STATE OF NORTH CAROLINA  
DEPARTMENT OF TRANSPORTATION

STATE PROJECT: 40238.1.4 (U-4902D)  
F.A. NUMBER.: NHS-0017(76)  
COUNTY: New Hanover

DESCRIPTION: US 17 Business (Market Street) from Lendire Road to Marsh Oaks Drive

SUBJECT: Geotechnical Report Addendum – Rock Plating Recommendations

PROJECT REFERENCE NO.	SHEET NO.
U-4902D	EC-18/CONST.10
RW SHEET NO.	U-4902CD-18
ROADWAY DESIGN ENGINEER	HYDRAULICS ENGINEER

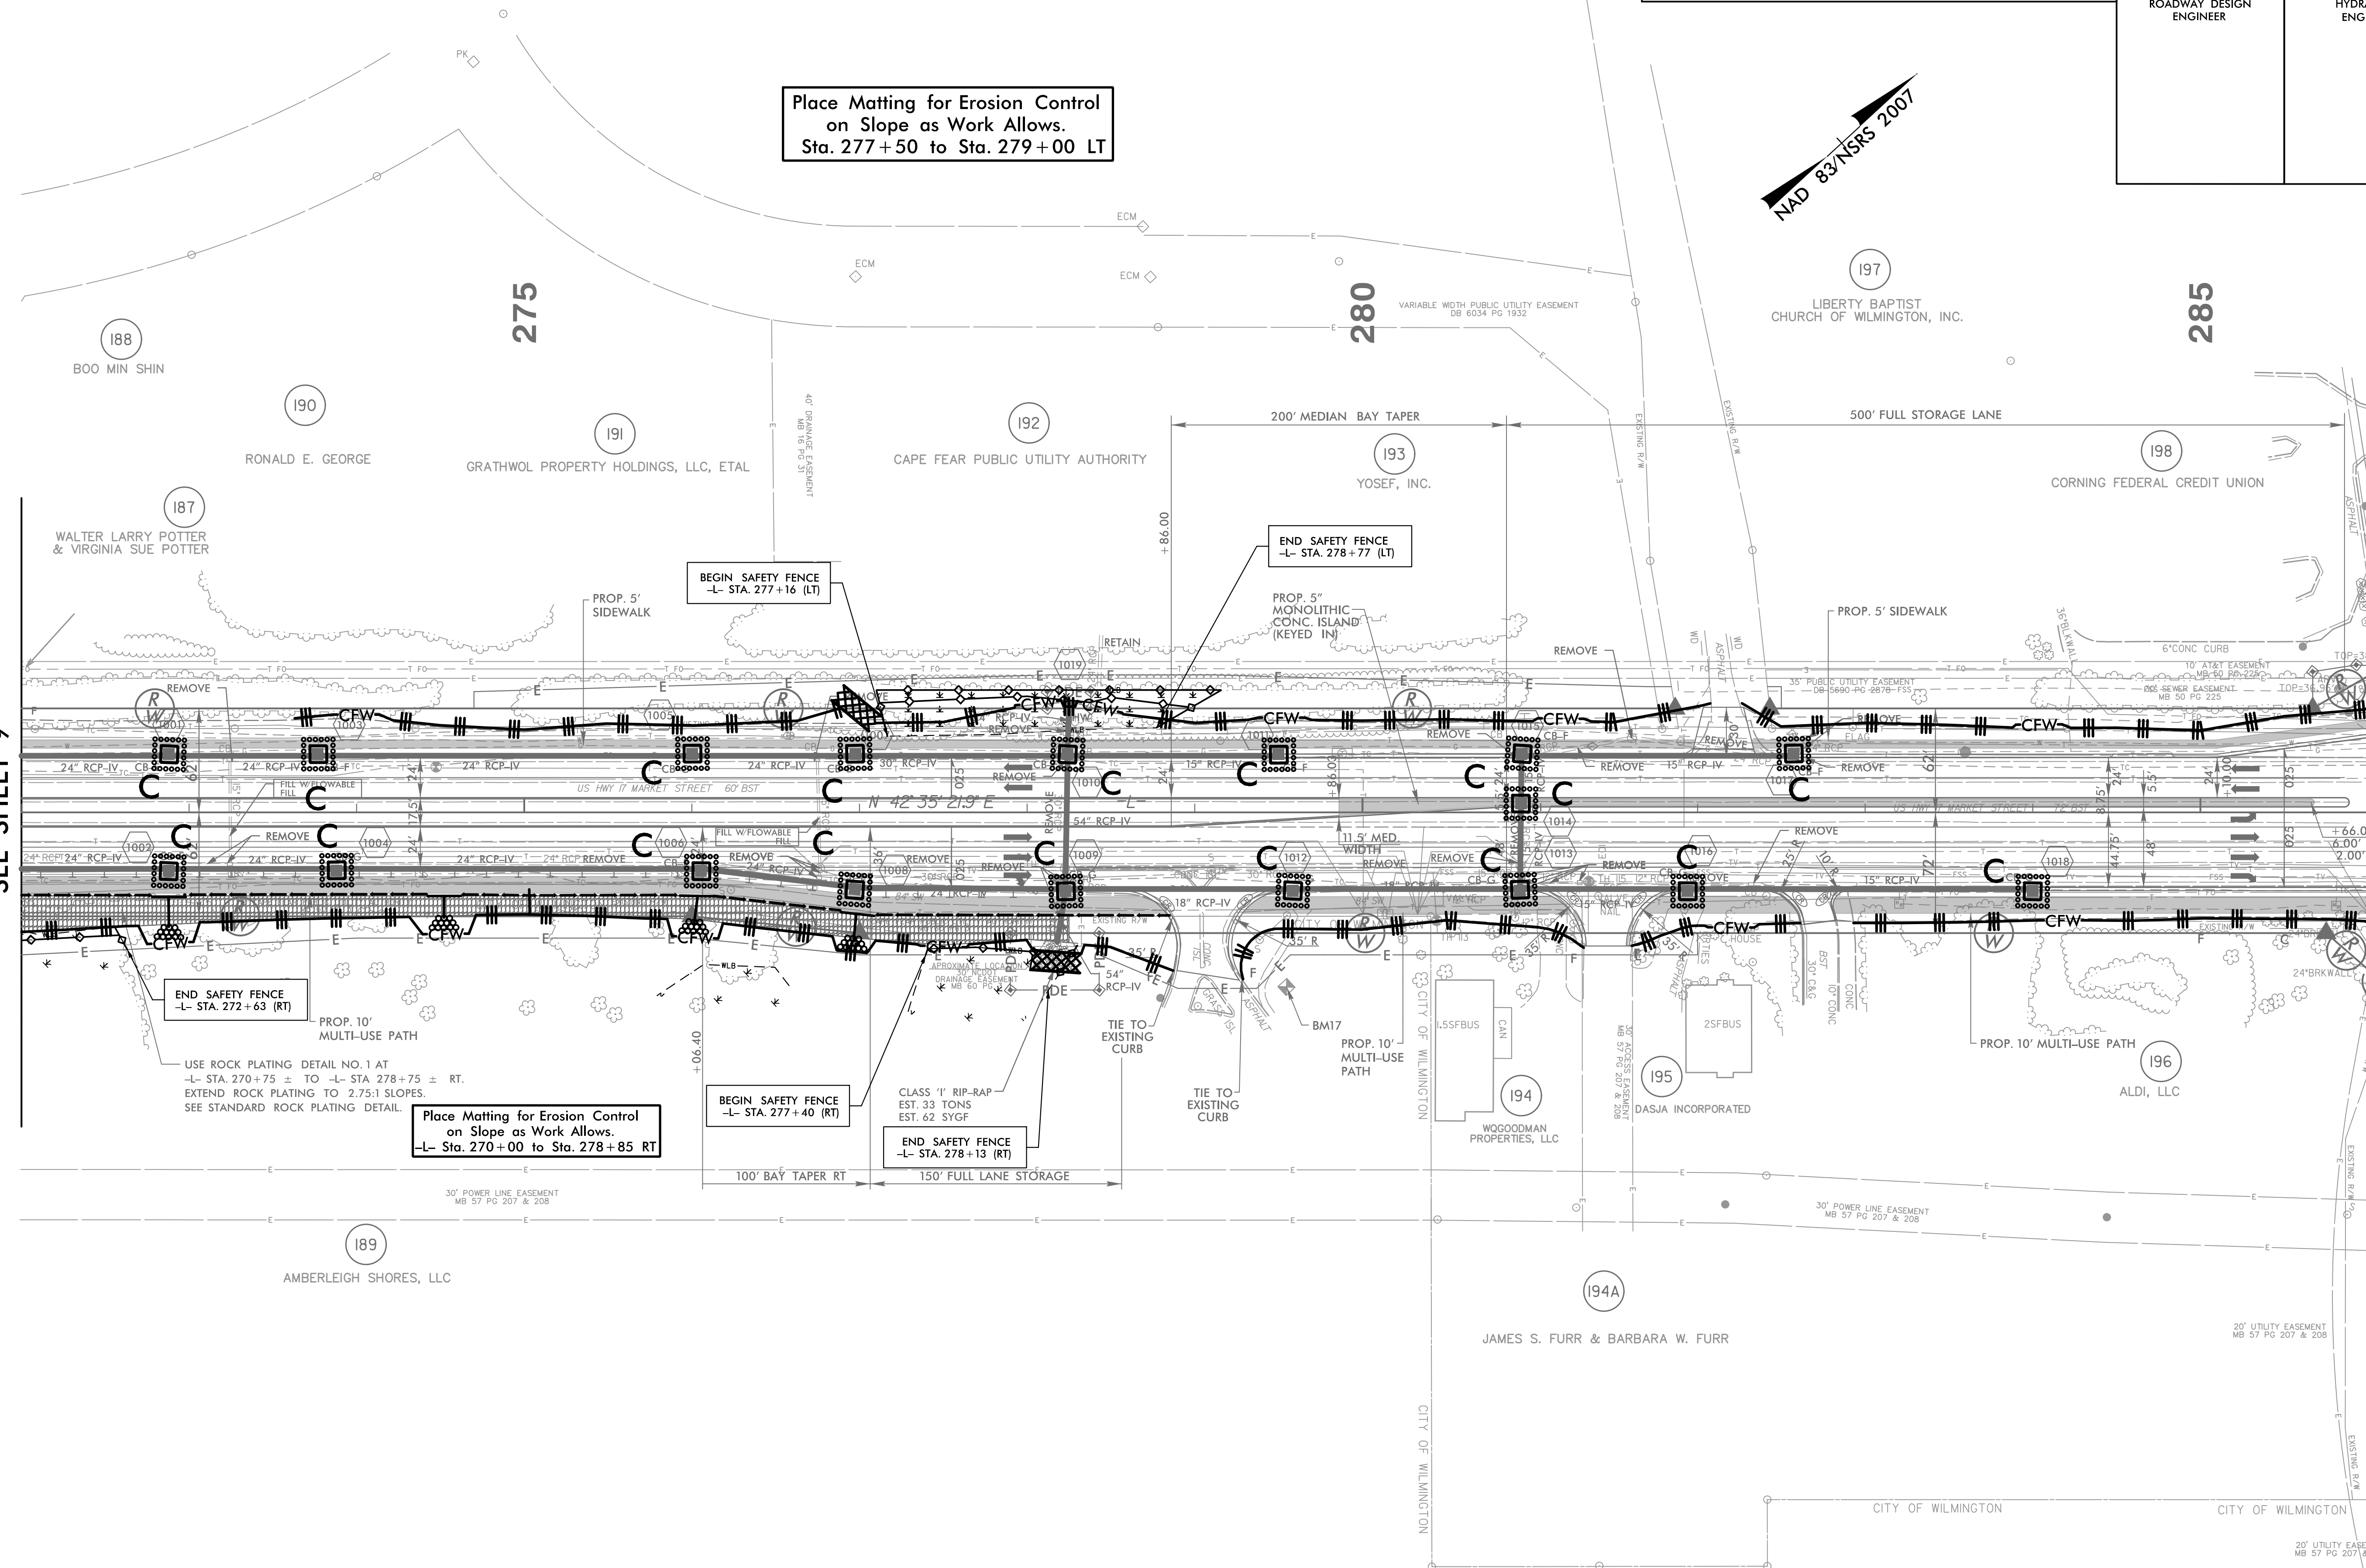
<u>Line</u>	<u>Station(±)</u>	<u>Location</u>
-L-	270+75 ± to 278+75 ±	RT

Use the Standard Rock Plating detail No. 1 of the Standard Drawing No. 1802.01 as shown on the Roadway plans. The estimated quantity for rock plating is 1600 square yards. Rock Plating is outlined in the Section 275 of the 2012 Standard Specifications. The following note should be added to the Roadway Plans:

“USE ROCK PLATING DETAIL NO. 1 AT -L- STA 270+75± TO -L- STA 278+75±, RIGHT. EXTEND ROCK PLATING LIMITS TO 2.75:1 (H:V) SLOPES. SEE STANDARD ROCK PLATING DETAIL.”
